# KIRKLEES METROPOLITAN COUNCIL

### UPDATE OF LIST OF PLANNING APPLICATIONS TO BE DECIDED BY STRATEGIC PLANNING COMMITTEE

**Planning Application 2016/92029**

**Erection of extension to existing Kingsgate Shopping Centre to form new Leisure Development including new cinema and restaurants, and demolition of existing buildings on the site including 20-22 Cross Church Street (partly within a Conservation Area)**

Content **ART LOCATION PLAN**
 Client **WD KINGSGATE LTD**
 Project **KINGSGATE LEISURE**

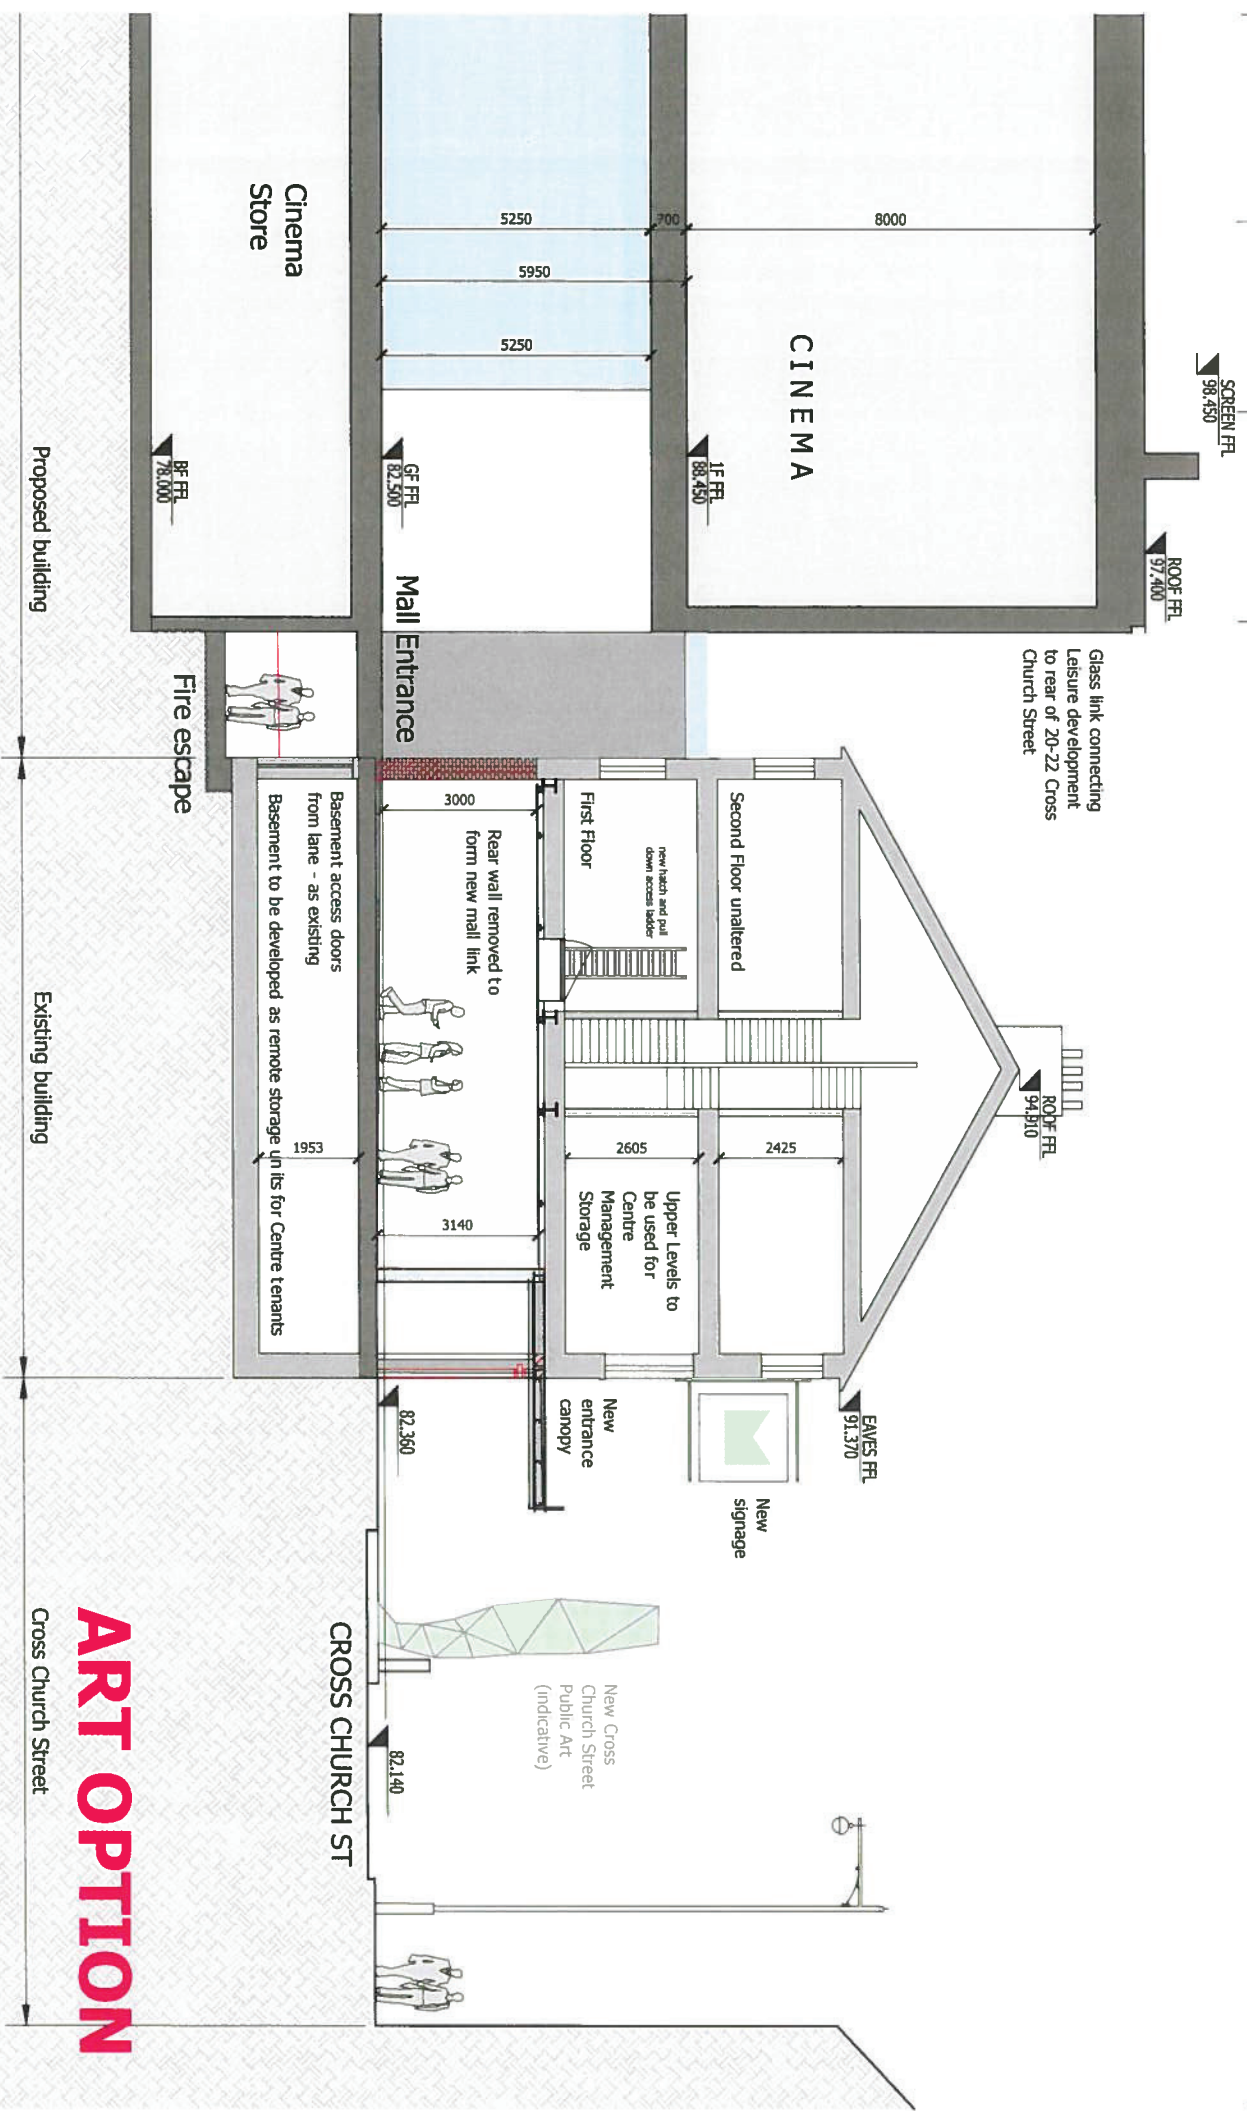
- Removal of the proposed canopy from 20-22 Cross Church Street. The alternative proposal for marking the entrance is to propose a hanging sign at first floor level, and a proposal for public art work on Cross Church Street.
- The introduction of a flat roof section to the proposed retail extension where the proposal abuts the former Palace Theatre.

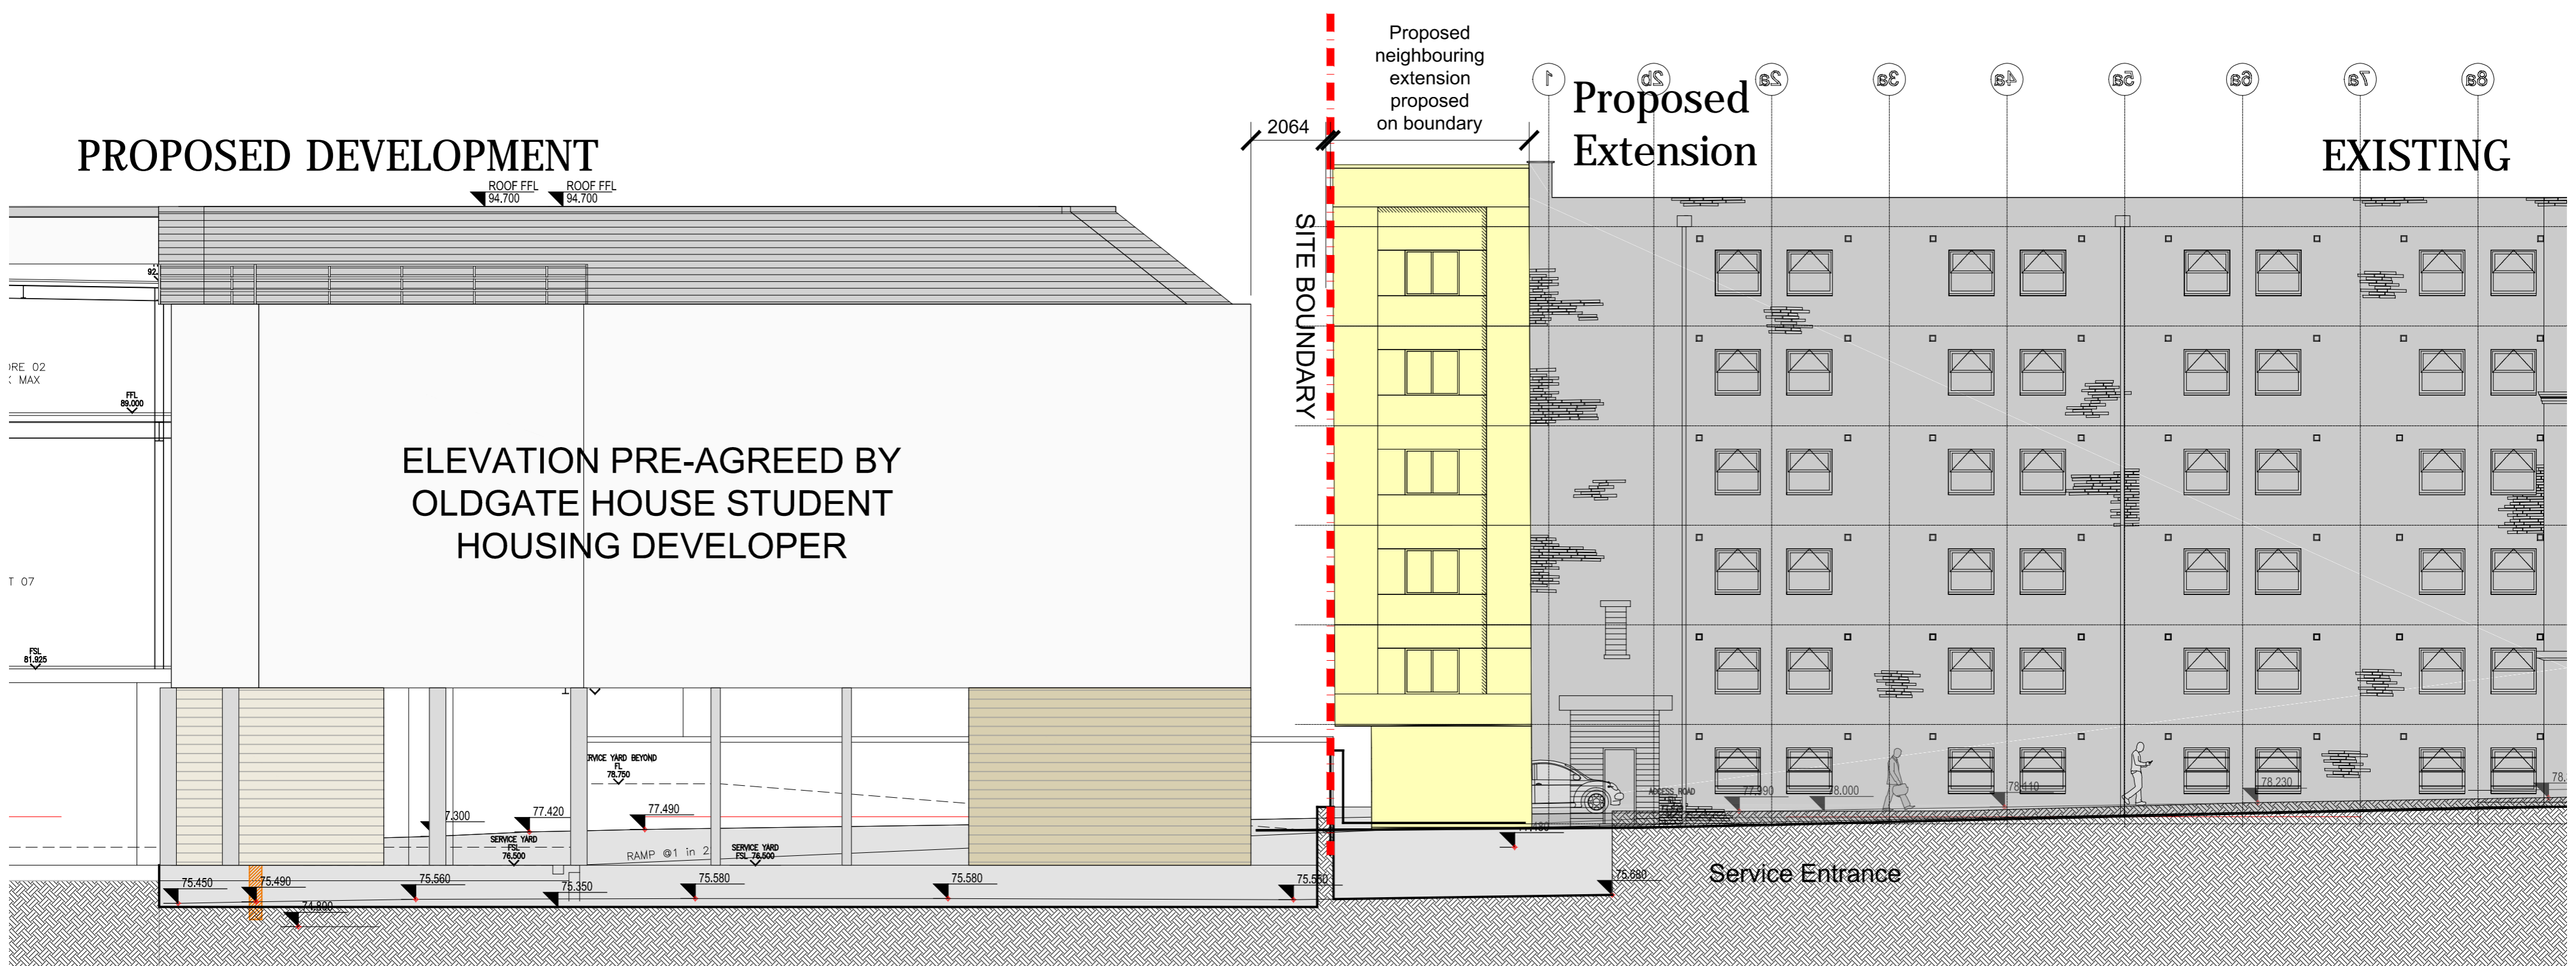
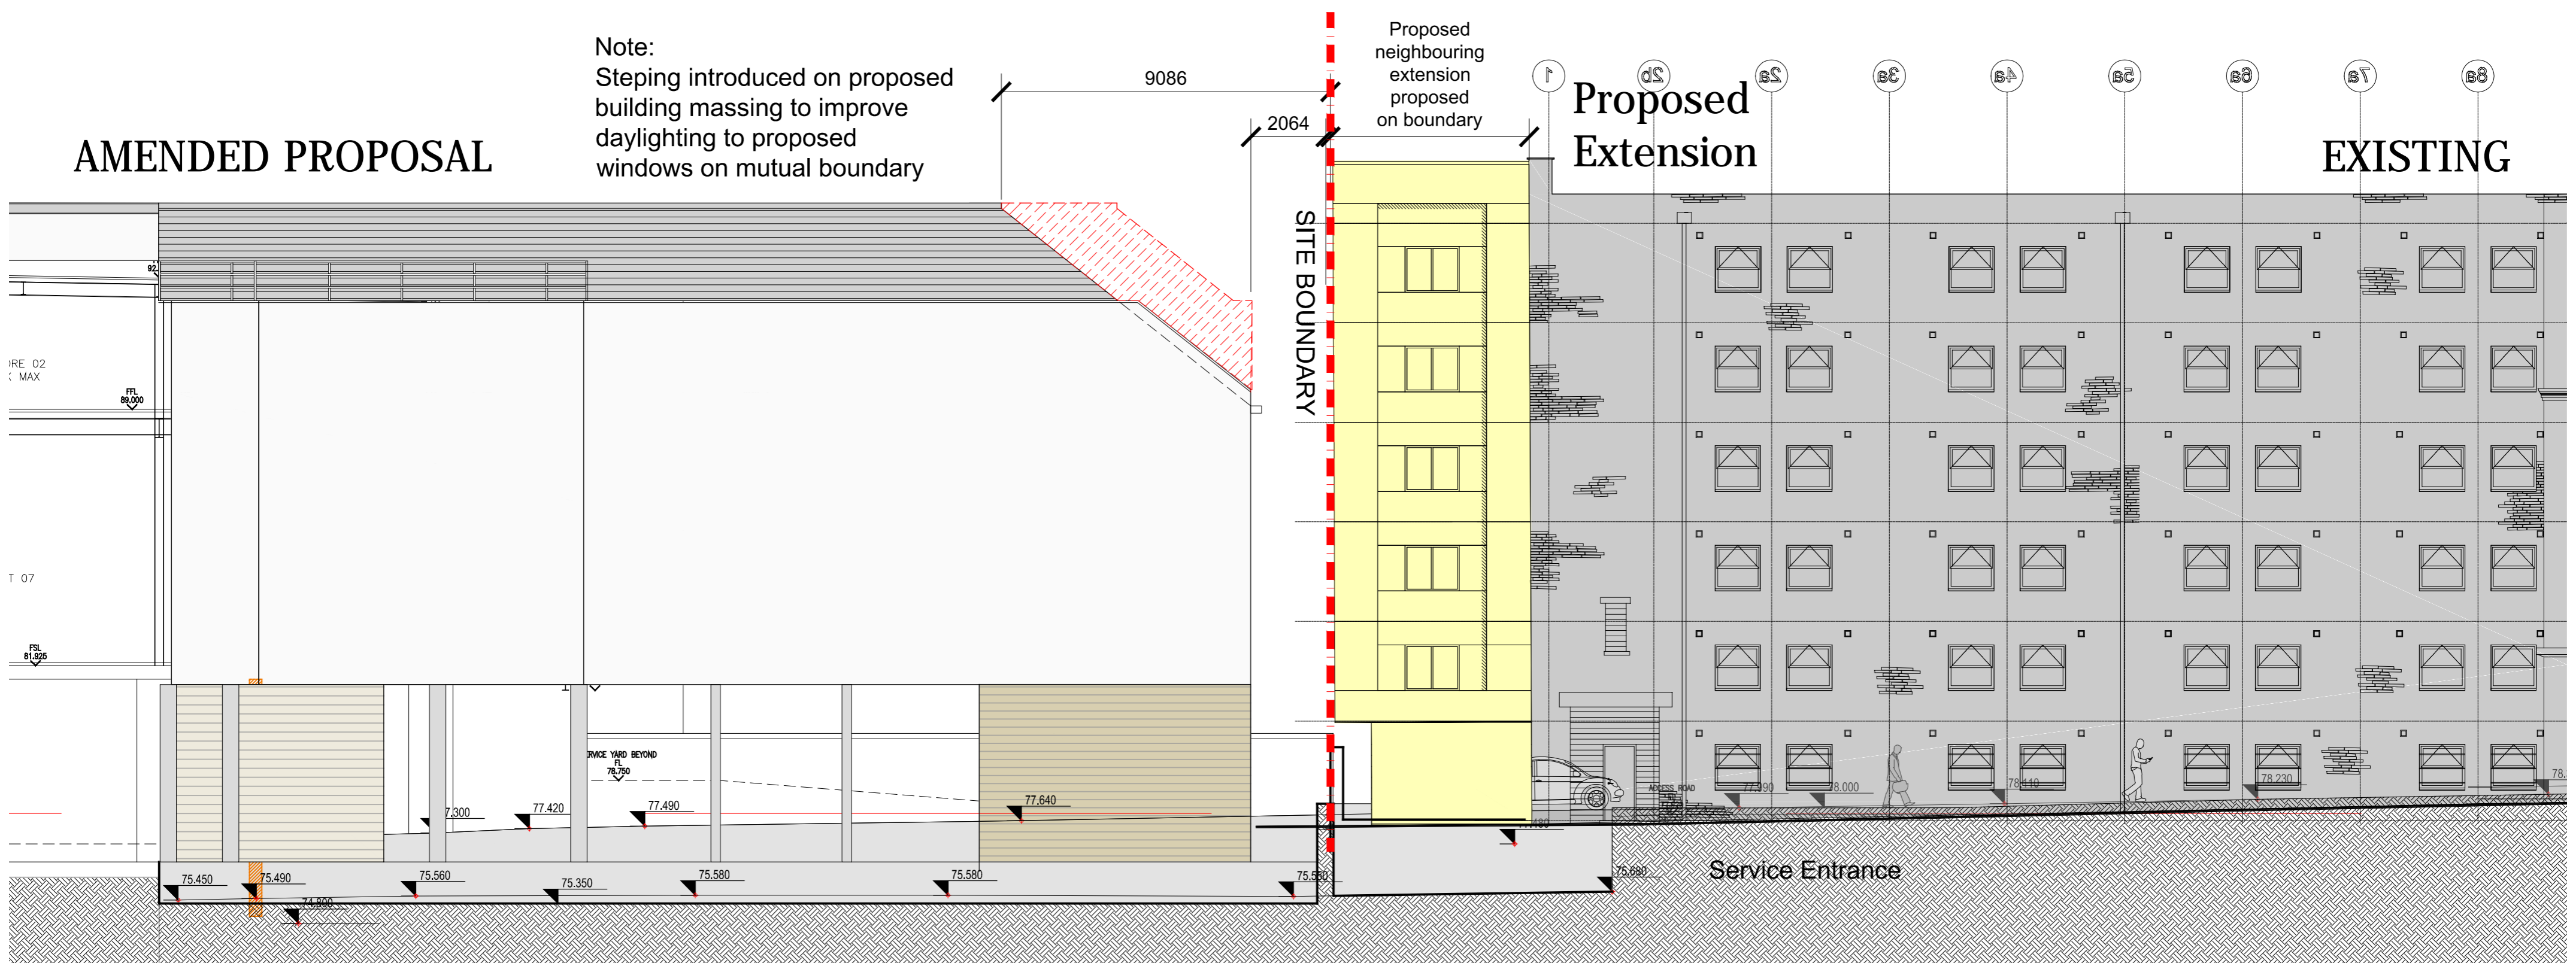
The proposed extension would have a close relationship with the student accommodation in the former Palace Theatre. This is made more acute by a recent planning approval (2016/91196) for an extension to the south of the former theatre to create additional units.

Officers have negotiated with the applicant to secure a further revision to the roof of the proposed retail extension to mitigate the concern about loss of light to habitable room windows. The scheme now proposes a flat roof section which further increases the separation distance to improve the amenity as a result of increased light to the flat windows. This is considered overall as much as reasonably can be achieved. Weighing everything in the balance, it is considered the proposed regeneration benefits weigh in favour of the proposal.
